RE: REVISED DRAINAGE PLAN FOR TRAVELODGE MOTEL (L-22/D50) REVISION DATED OCTOBER 18, 1989

RE: DRAINAGE PLAN FOR TRAVELODGE MOTEL (L-22/D50) RECEIVED SEPTEMBER 29, 1989

TRAVELODGE  
 MOTEL  
 GRADING and  
 DRAINAGE PLAN

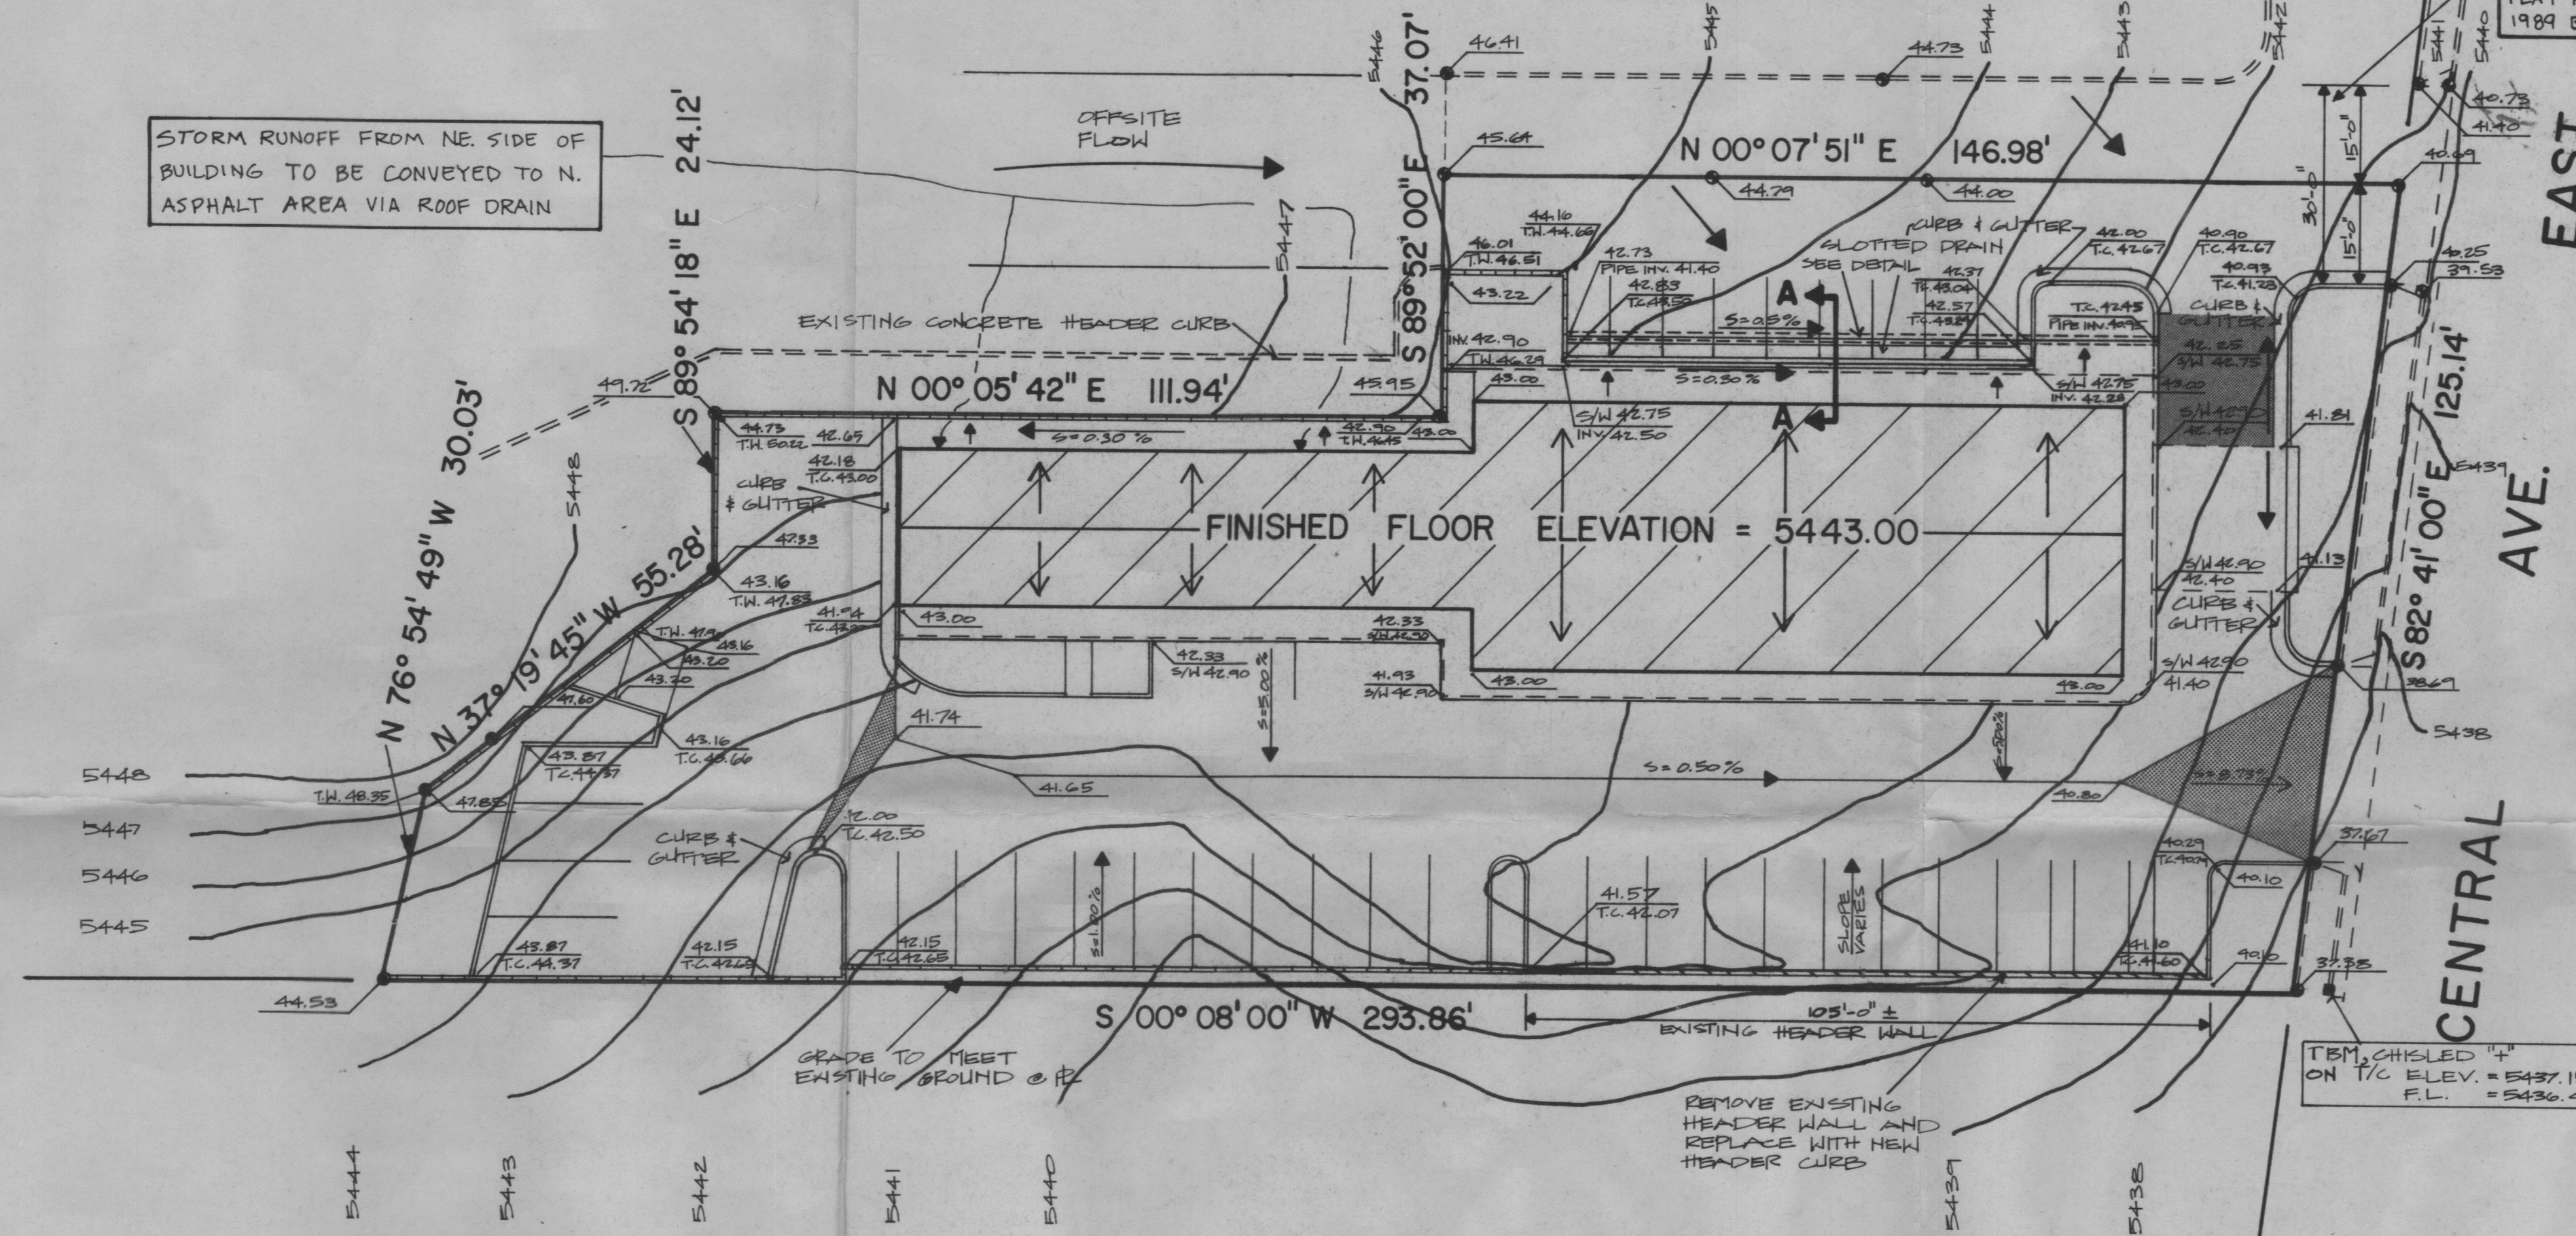
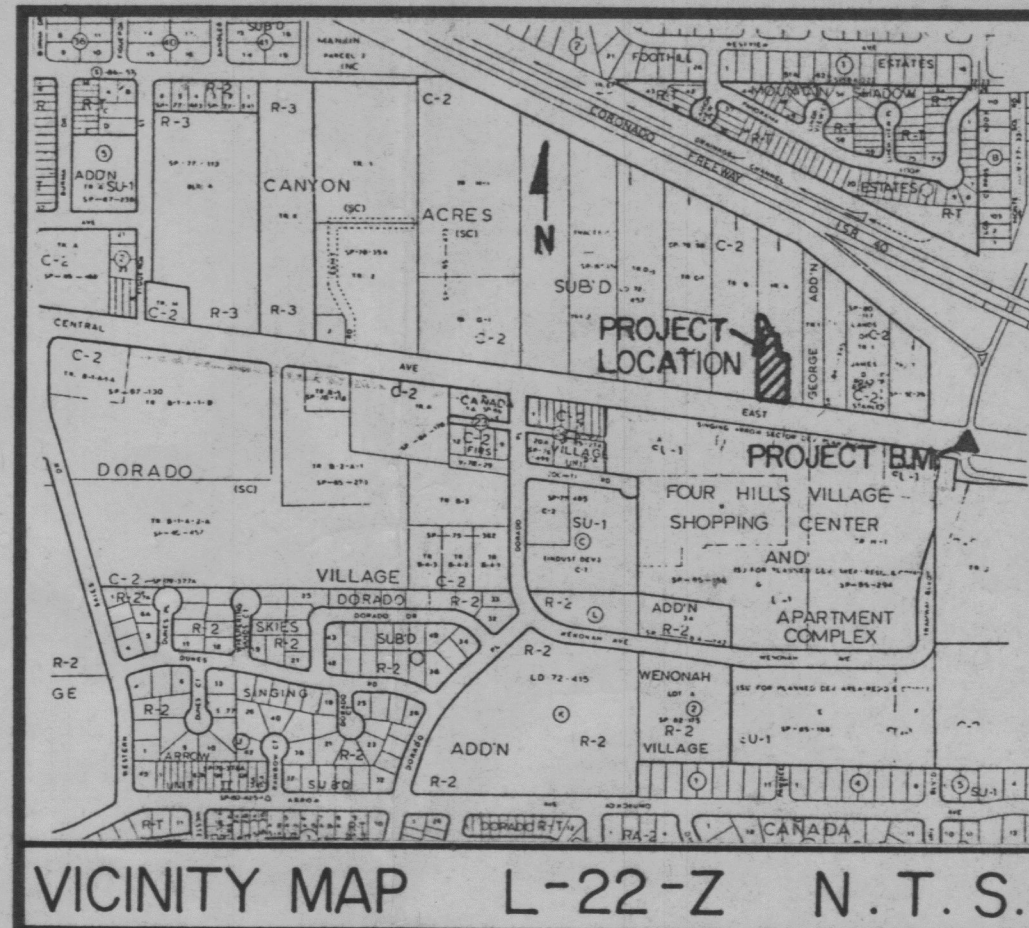
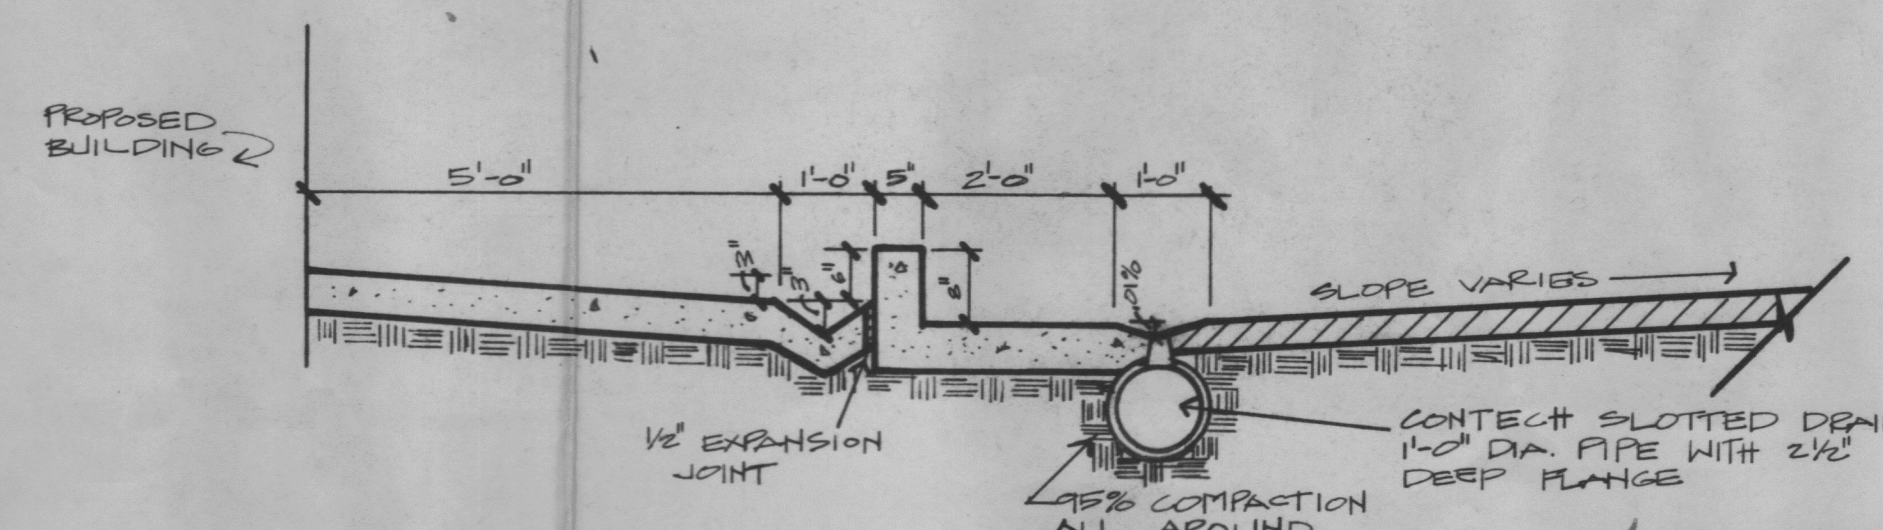
- 1. How will the roof runoff on the northeast side of the proposed building be routed towards the north portion of the asphalt area? Your plan indicates a curb or wall.
- 2. Please indicate your proposed contours.
- 3. Your existing contours on the northwest corner of the property indicates you may be accepting offsite flows, please address.
- 4. T.B.M. must be established within the site limits. Location, description and elevation.
- 5. Copy of plat showing the 30' common access and utility easement.

1. Roof runoff on the northeast side of the proposed building will be conveyed in roof drains to the northeast corner of the building. Any remaining runoff or splash will be drained away from the building at a minimum slope of 2 percent then routed towards the north asphalt area along the proposed retaining wall at a 0.30 percent slope.

- 2. Proposed contours are not shown on this plan due to the scale of the drawing. Adding proposed contours would clutter the drawing.
  - At present off-site flows also enter the site on the northeast corner of the property. These flows are considered insignificant, because a curb on the adjacent property diverts all developed flow to the southeast. Only a landscaped strip 30' X 40' in area is contributing to this site.
  - 4. T.B.M. has been added to plan.
  - 5. Copy of plat attached.
